**Re: Advertisement Planning Application for 'Williams&Glyn' Barnsley**

Premises ~ 13 Church Street, Barnsley S70 2TB

The client has instructed Pearce Signs Limited to amend the signage and I enclosed revised drawings for your attention.

ITEM 1 Fascia & Projecting Sign W&G-ES1.1-E, W&G-ES1.10-B
Scale 1:50

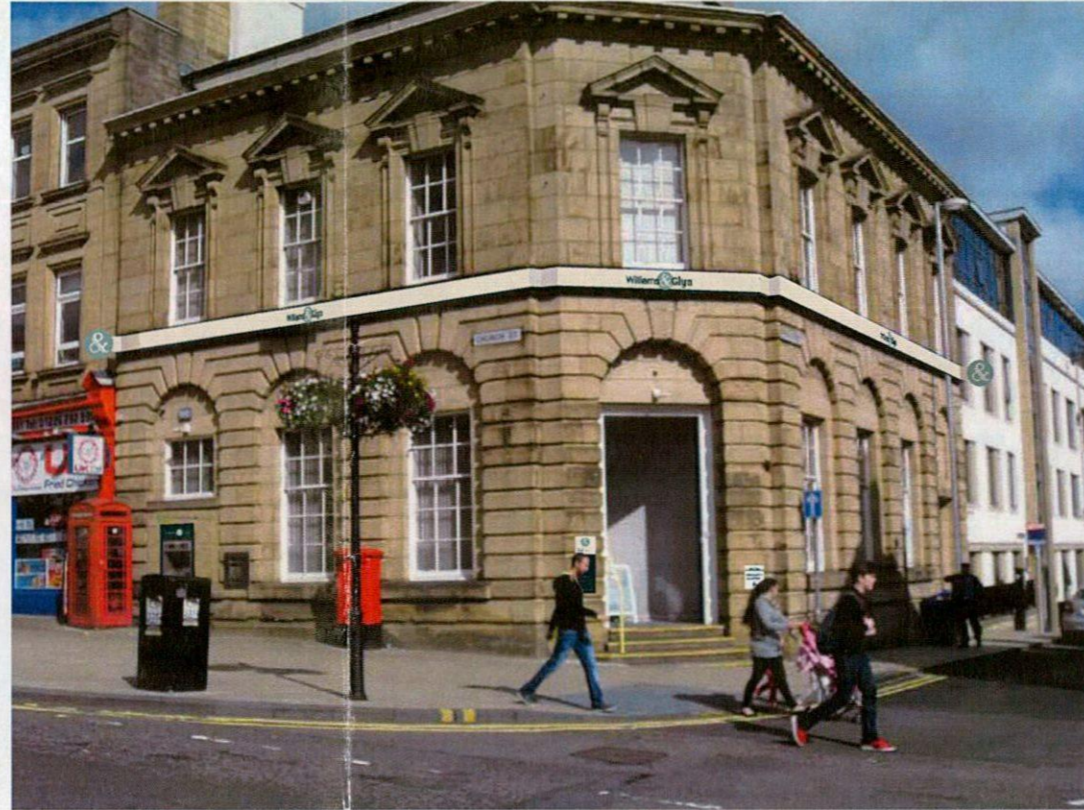
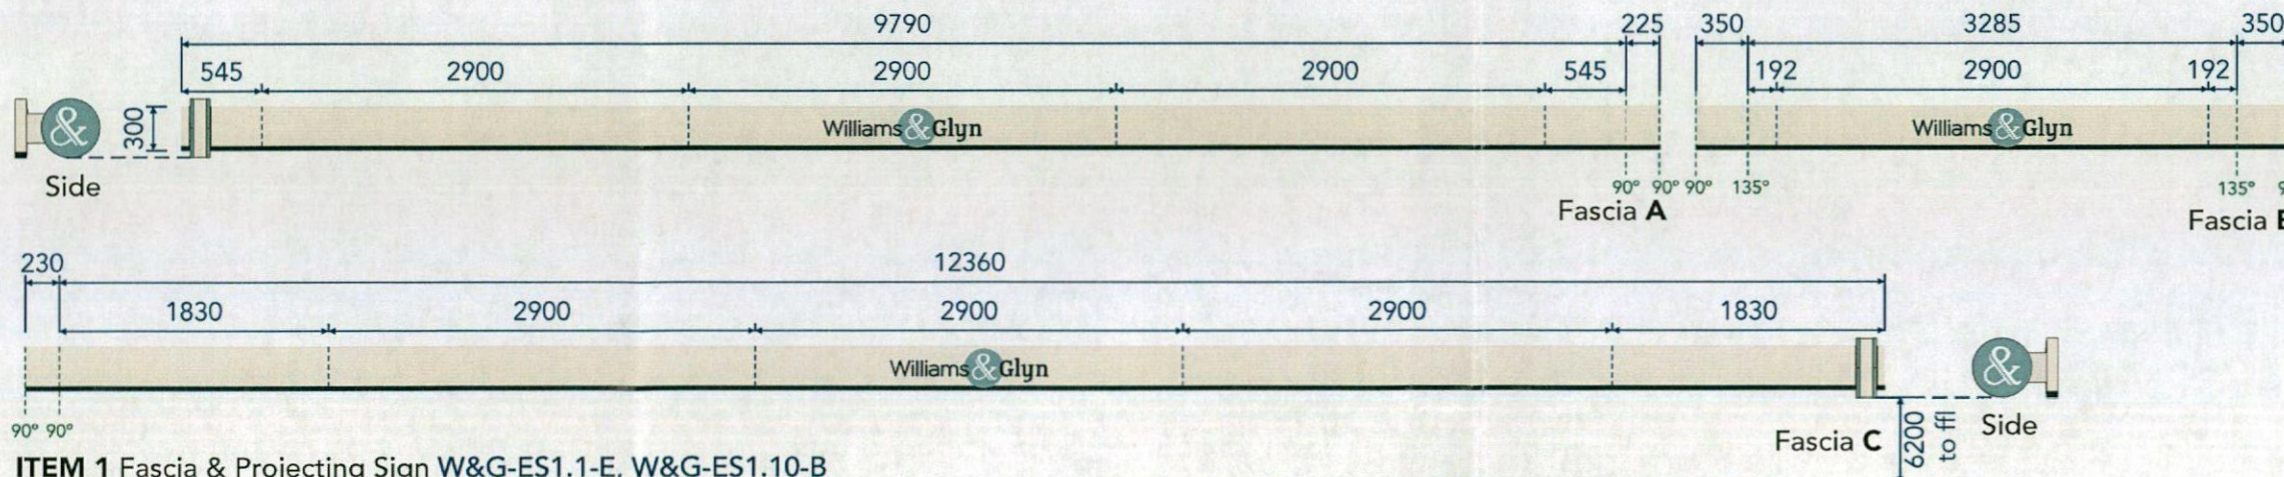
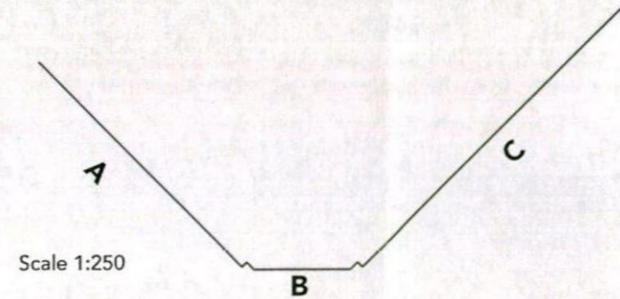
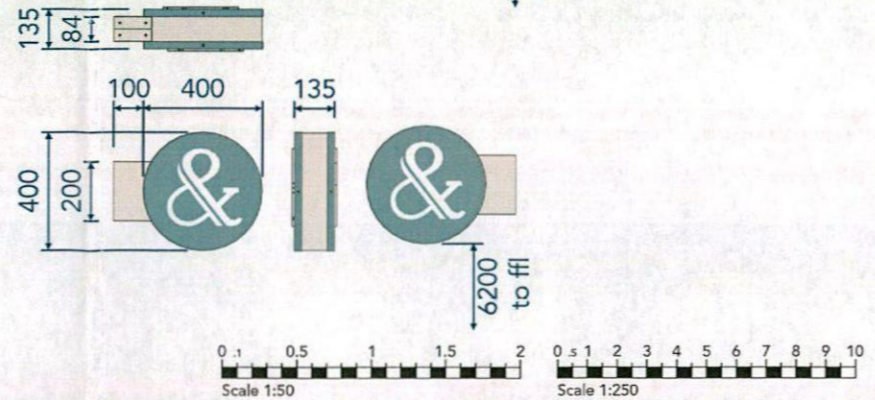
Revision concerns the Fascia signage which you will see is now proposed as 3no. 'badge signs' centred on respective elevations.
